Application for a non-material amendment following a grant of planning permission.

Erection of three detached dwellings Land at Old Lane / Tylor Lane, Scapegoat Hill, Huddersfield HD7	
Reference number:	2015/62/92476/W Approved on appeal
Date of decision	10/05/2017

6. Non-Material Amendment(s) Sought

Client:		BRIERSTONE		
Job:		Scapegoat Hill, Golcar		
Drawing title:		Plot 2 - Elevations - sheet 1.		
Drawing Number: (Job number)		M4724-2	21	01 Revision:
Scale:		1 : 50 @ A1		
Date:		01.12.2020		
Drawn by/ checked by:		CS

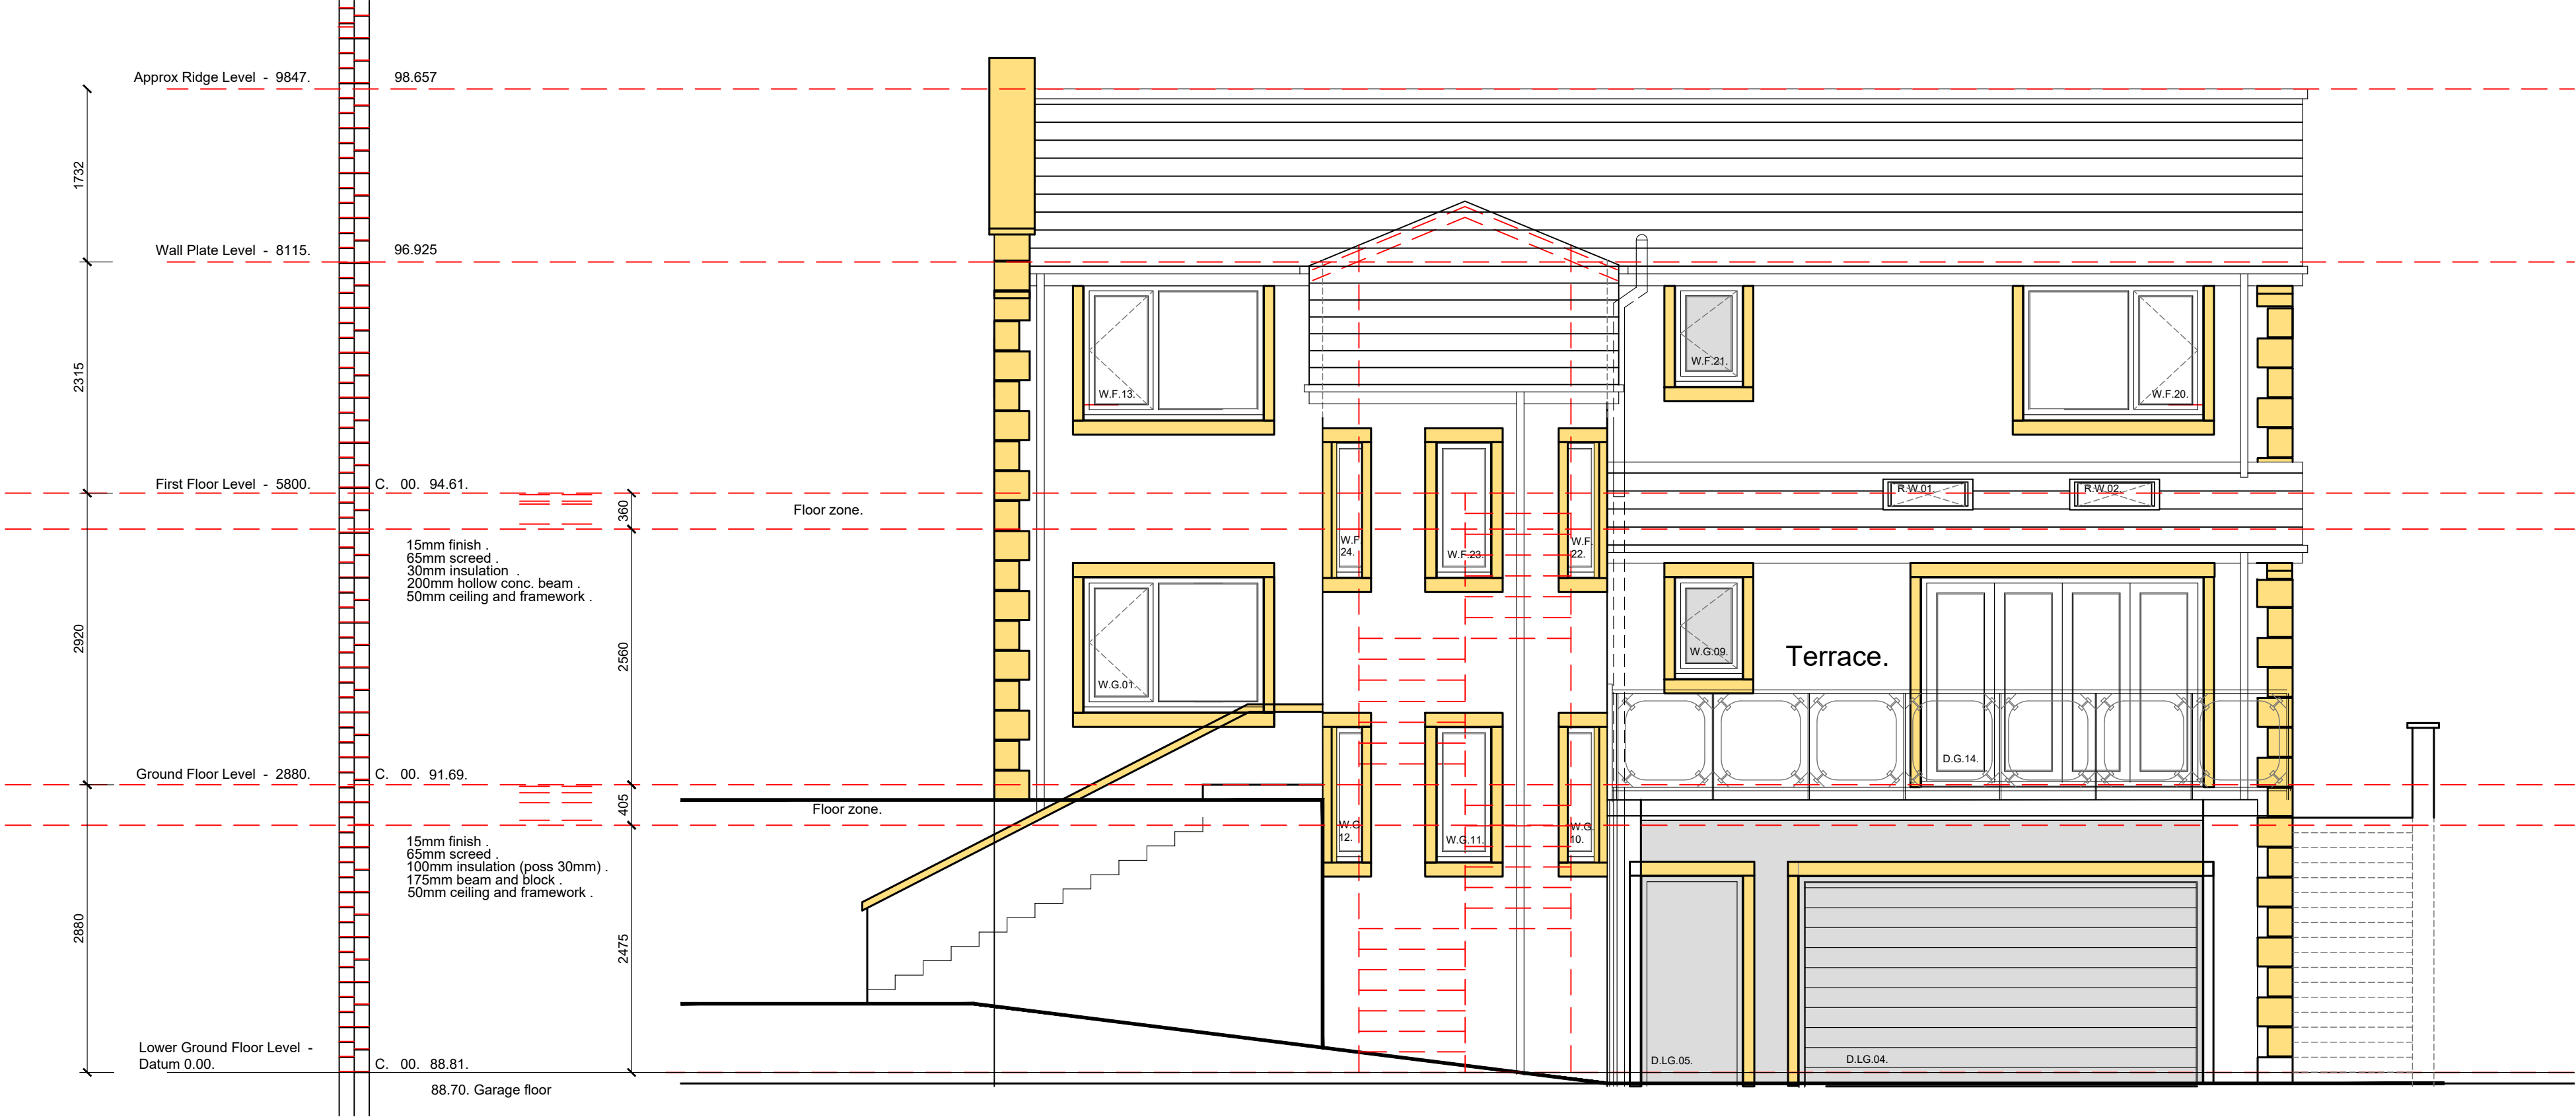
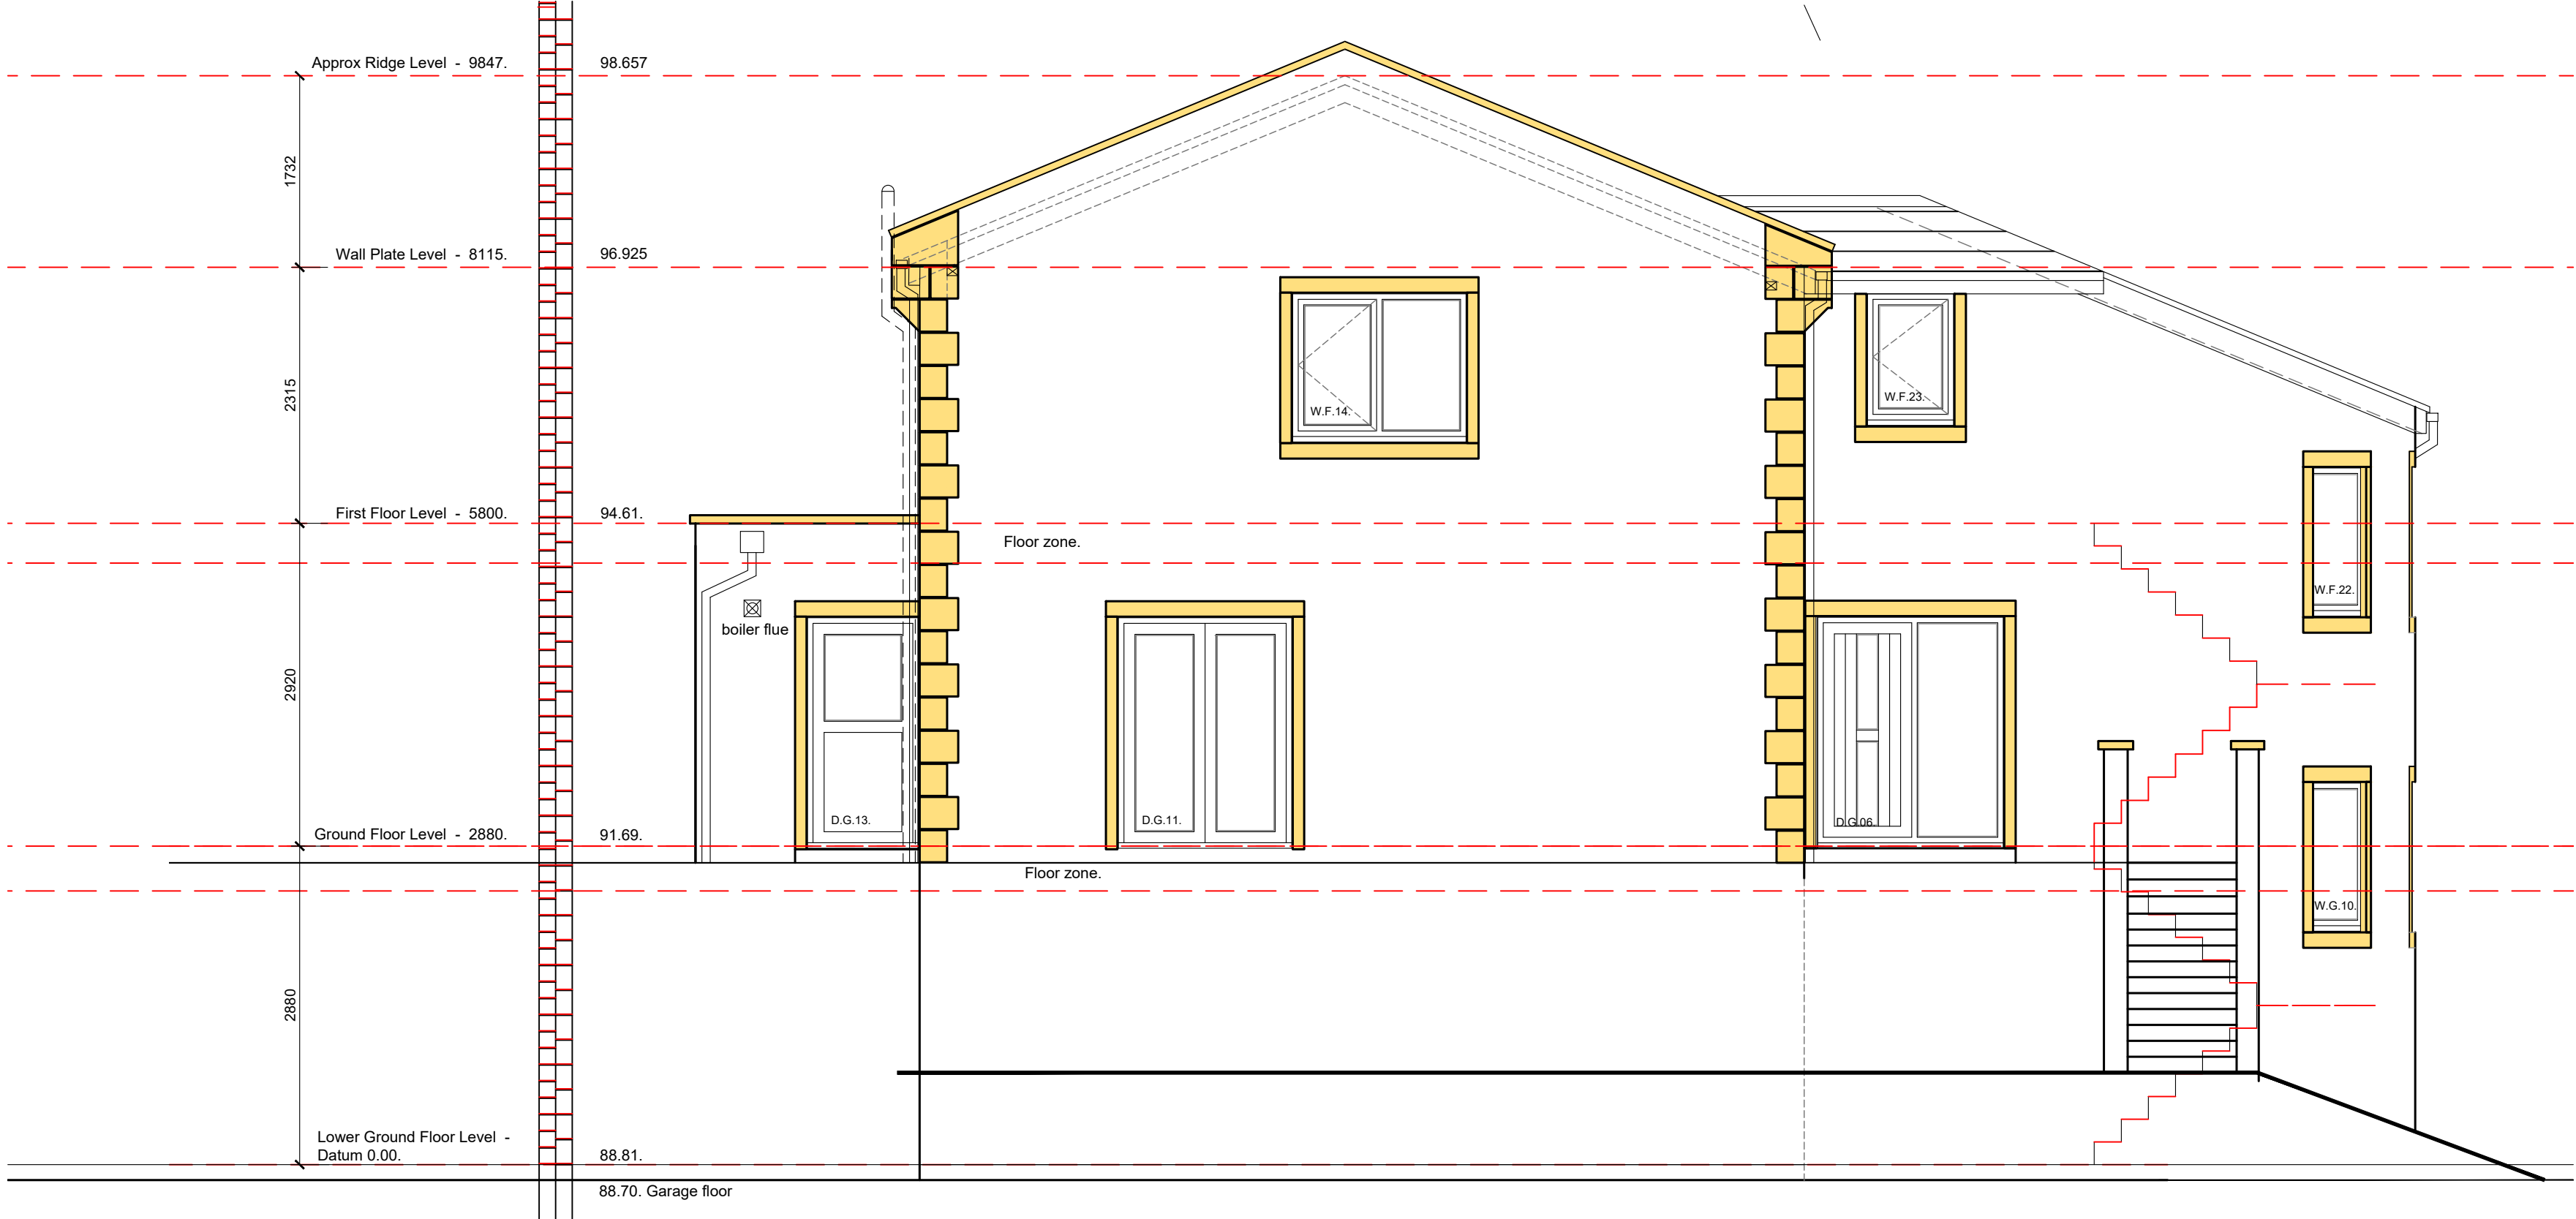
- Removal of lift
- Additional windows to utility / kitchen
- Removal of rooflights to kitchen
- Window added to ground floor WC
- Conservatory amended to incorporate within kitchen / terrace
- Patio doors added to lounge in-lieu of window
- Juliet balcony amended to window to first floor
- Alterations to rear elevation first floor
- Alterations to roof
- Alterations to fenestration of windows to staircase structure
